SHOALHAVEN CITY COUNCIL
ENVIRONMENTAL ASSESSMENT SUBMISSION TO THE NSW DEPARTMENT
OF PLANNING PART 3A, ENVIRONMENTAL PLANNING & ASSESSMENT ACT, 1979

MAJOR PROJECT APPLICATION MP 06_0205

Vincentia District Centre
Modification No 5

PROPOSAL: Proposed MP06_0205 VDC Stage 1 - Modification No 5 being a modification to the VDC Stage 1 approvals issued in Modifications 2, 3, and 4.
Delivery of the VDC in two stages with an amended floor layout design and Statement of Commitments and proposals for a fuel and fast food outlet in Stage 1.

19m ARTICULATED VEHICLE
SWEPT PATHS

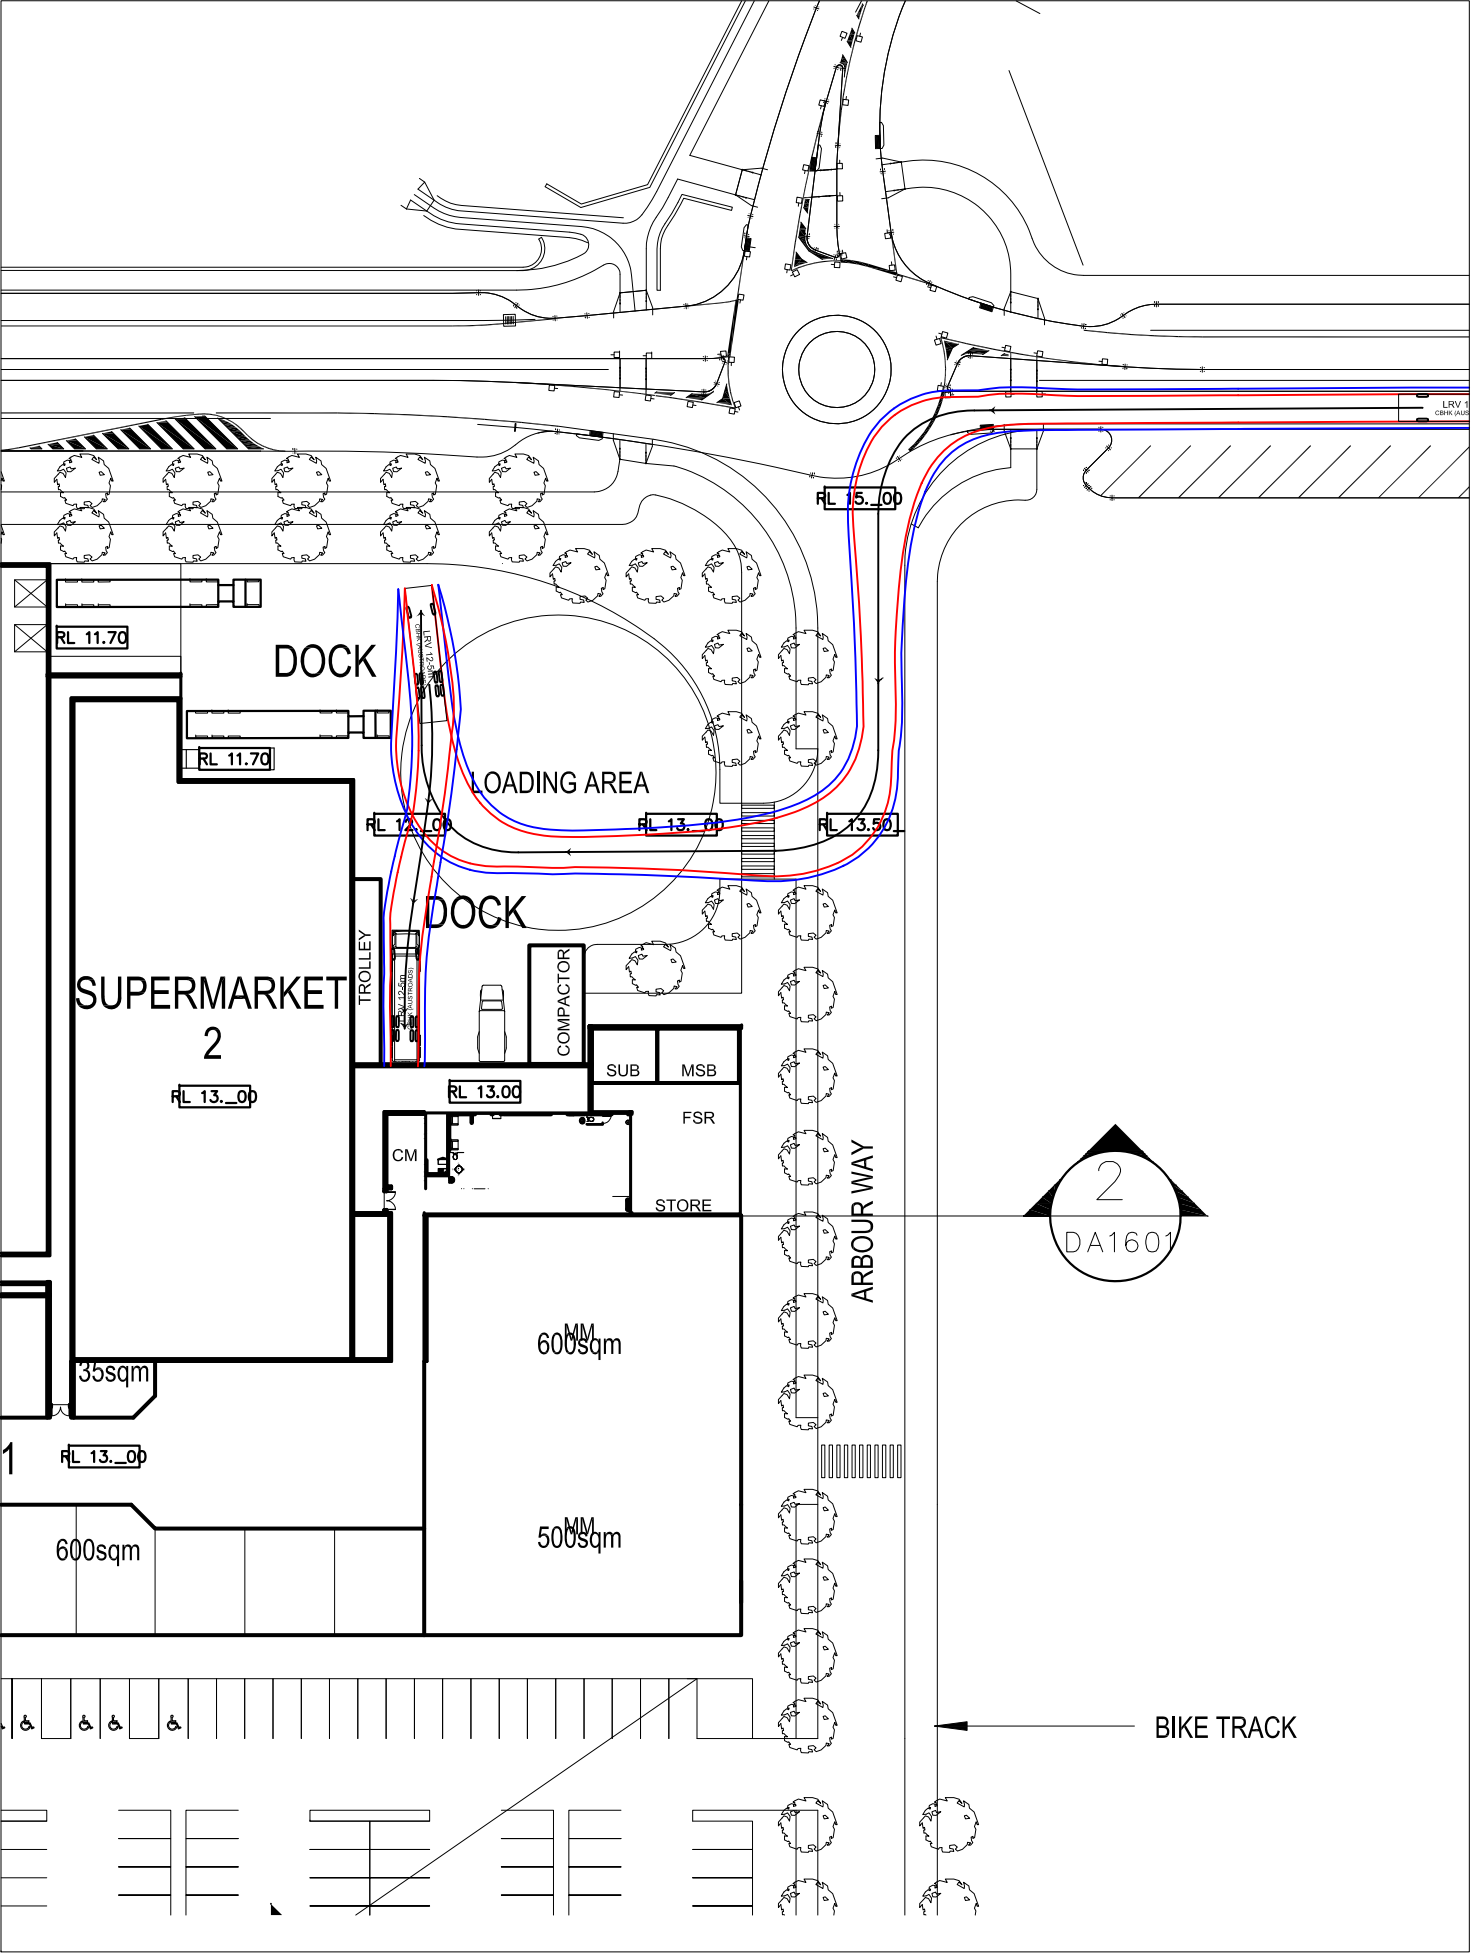
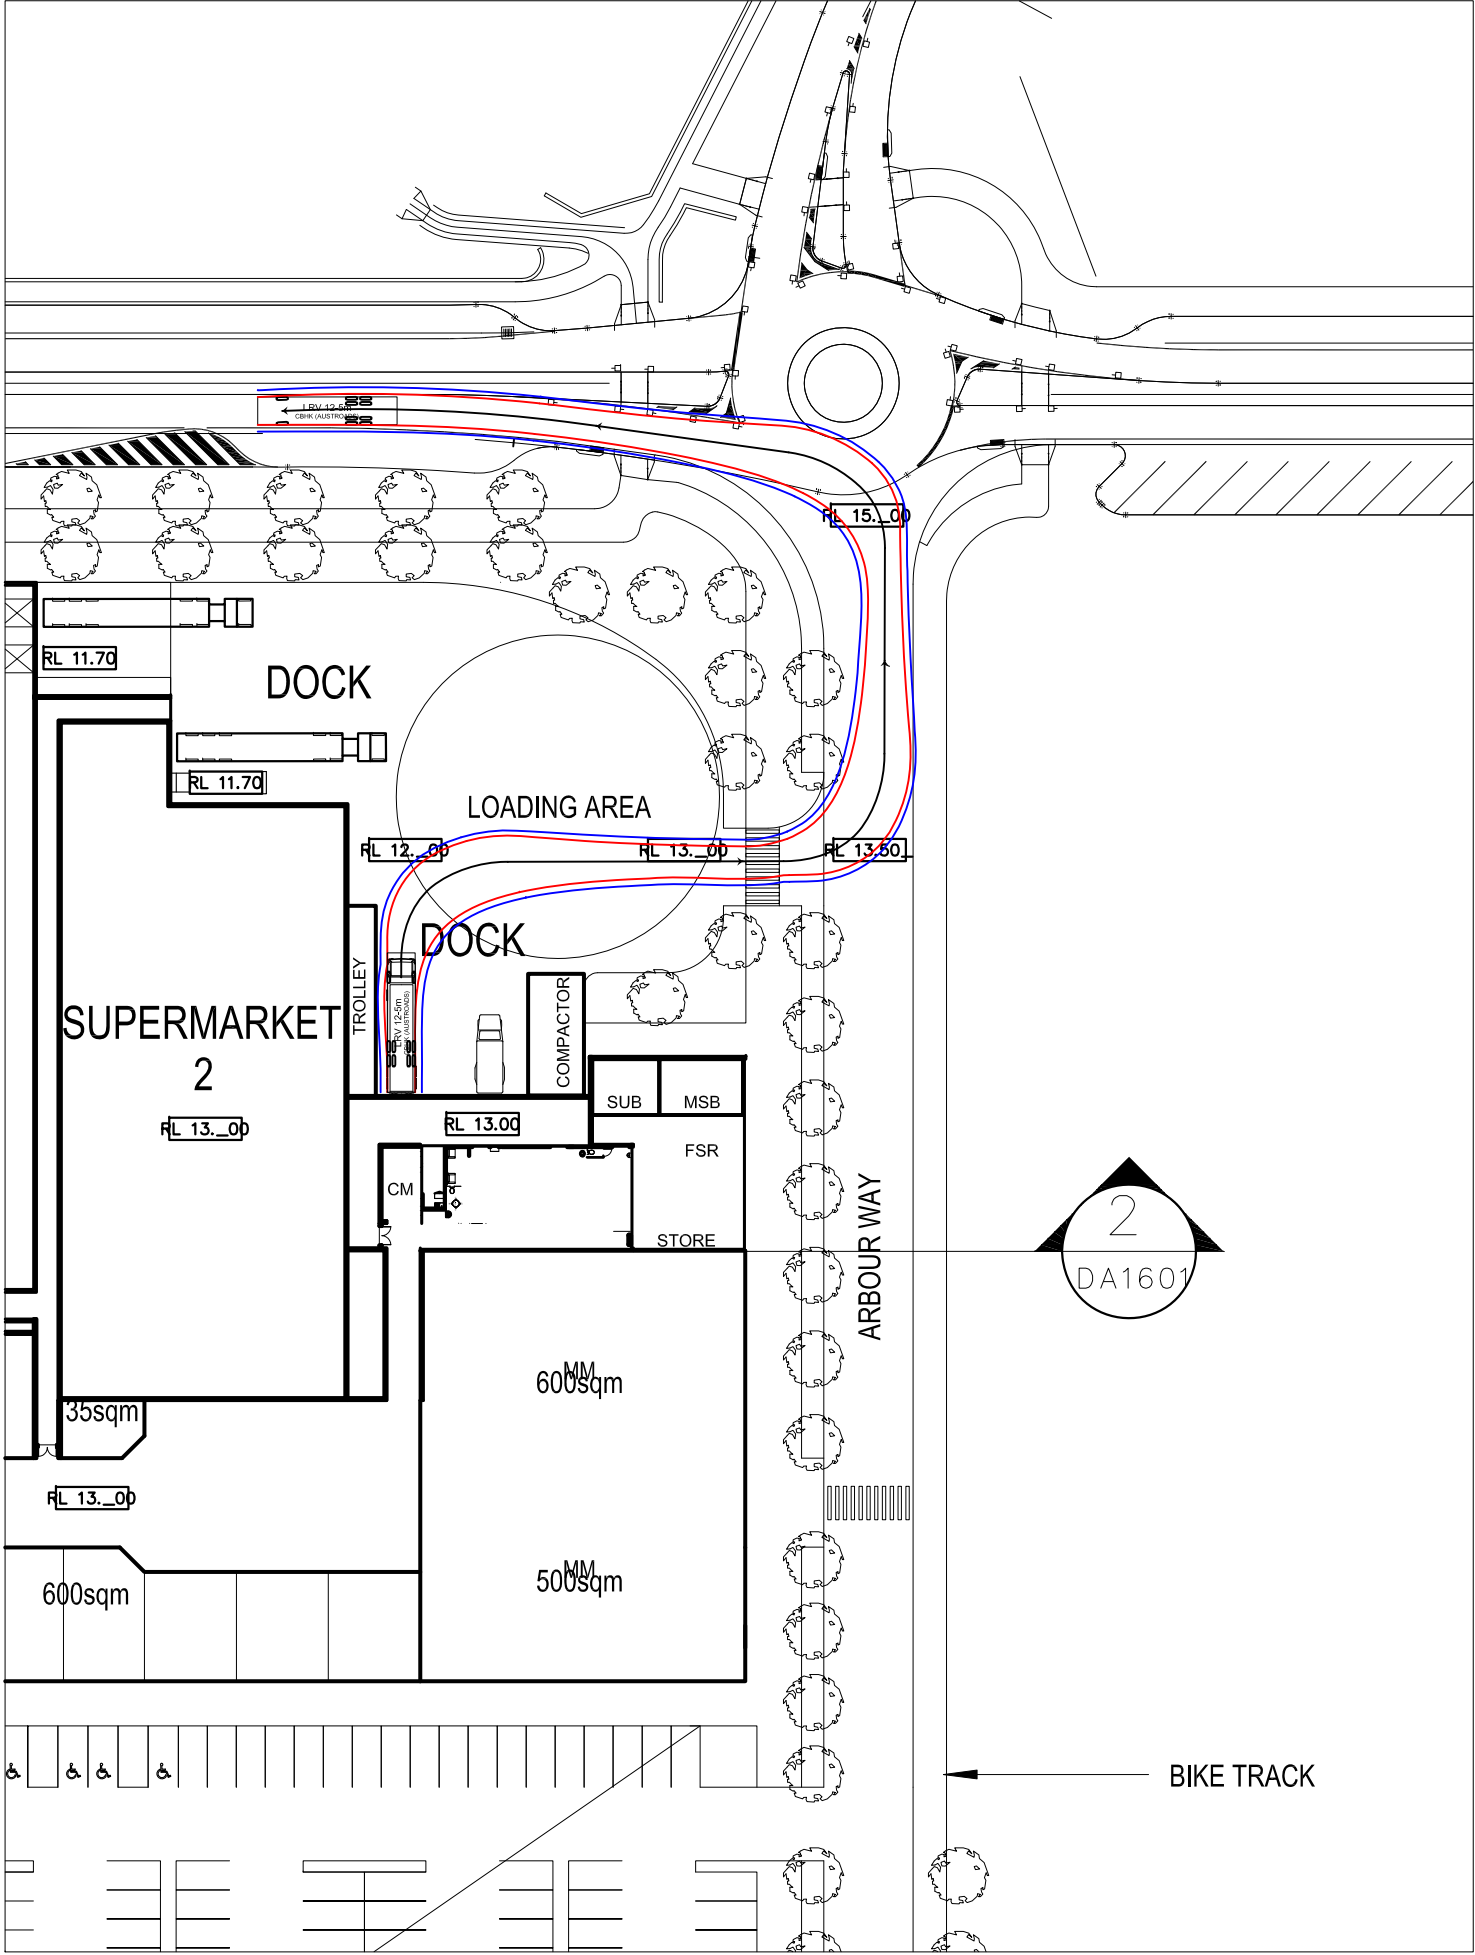
The Colston Budd Hunt & Kafes Pty Ltd (CBHK) Stage 1 report includes vehicle swept paths for the Stage 1 loading dock. However, the CBHK Stage 2 report does not include swept paths for the two loading docks for the retail and bulky goods buildings and this will be required to validate the practical use of the loading docks.

**Existing Thursday afternoon peak hour traffic flows plus Stage 2 development traffic**

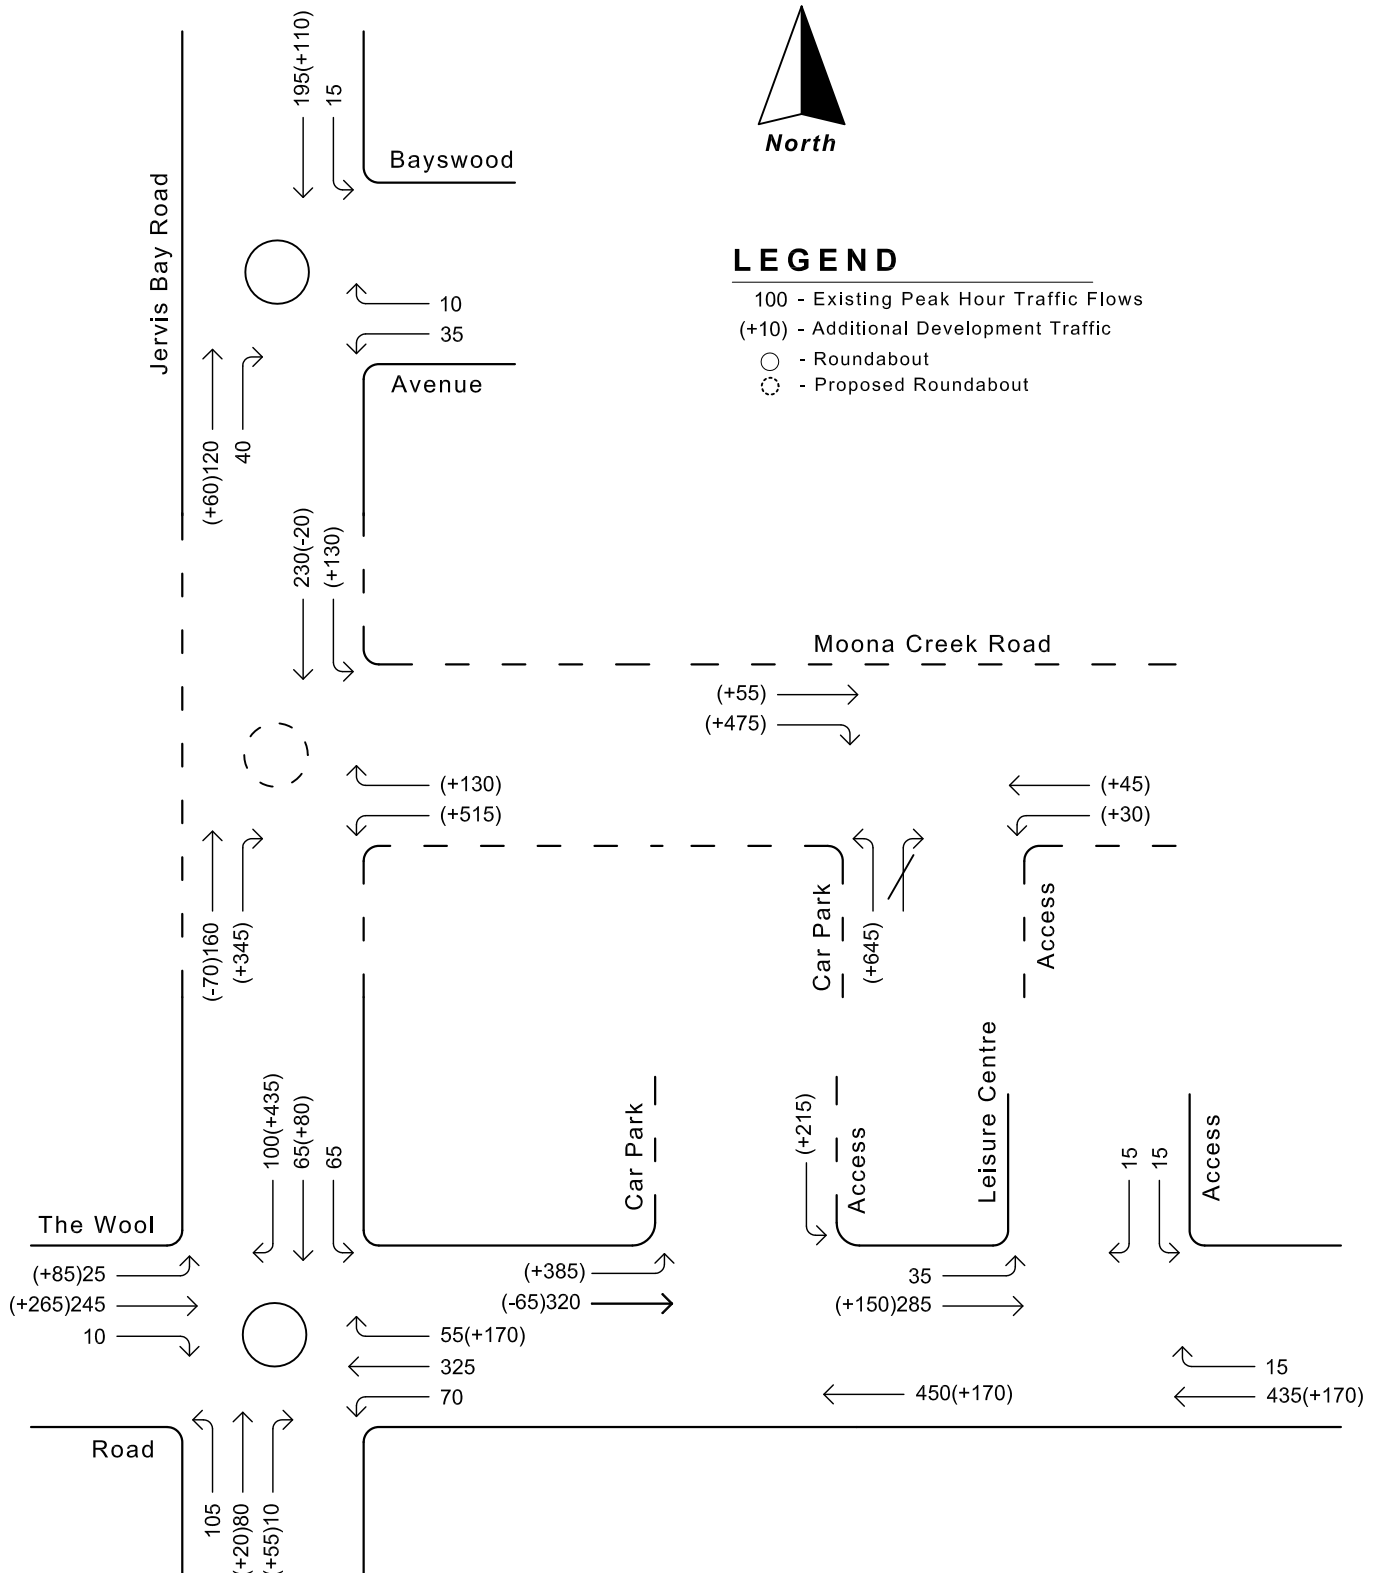
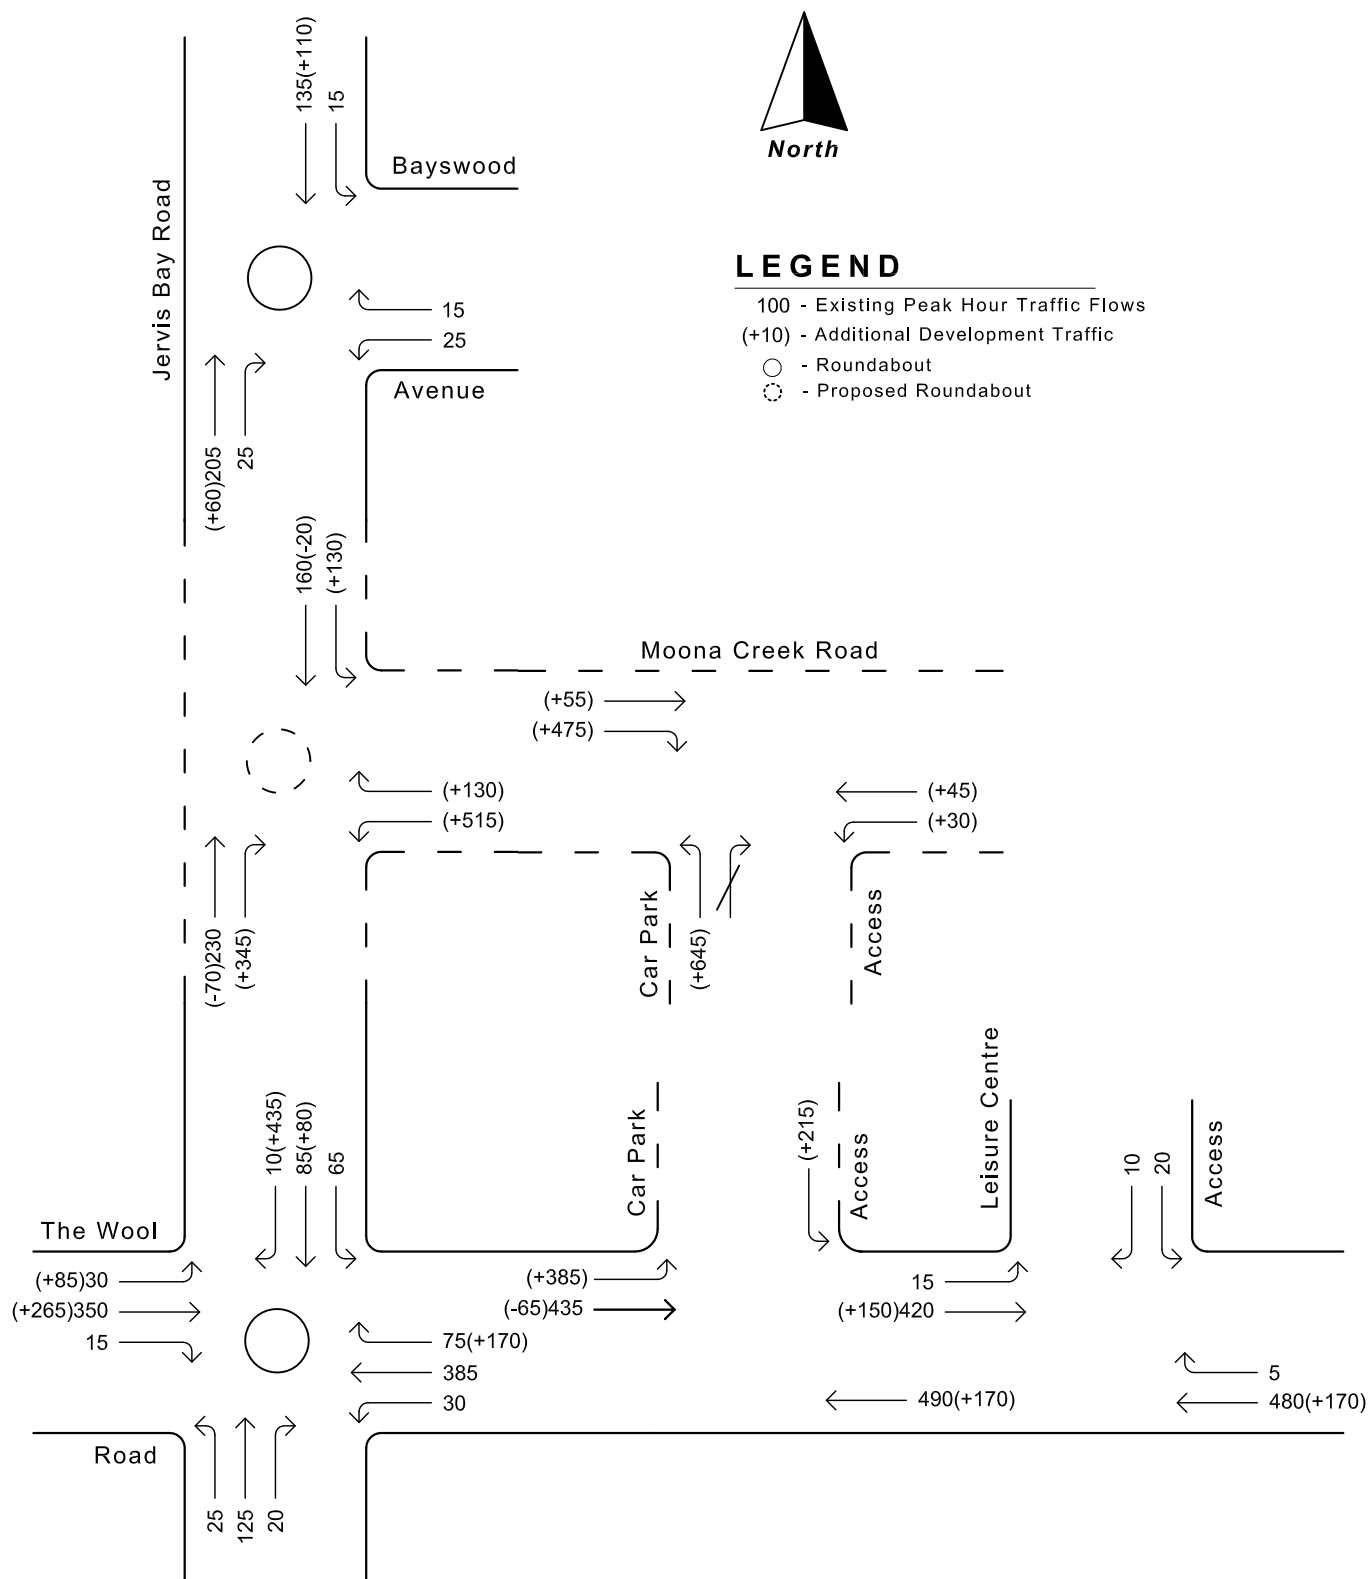
3.6.3.3 The existing roundabout at the NCR/TWR intersection provides for single lane movement. The CBHK Stage 2 report requires this roundabout be upgraded to two circulation lanes on all legs except the southern leg (Jervis bay Road).

It is considered that the requirements for this roundabout in the CBHK Report should be included as a Stage 2 SoC. This is consistent with SoC 51 of the Concept approval in 2007.
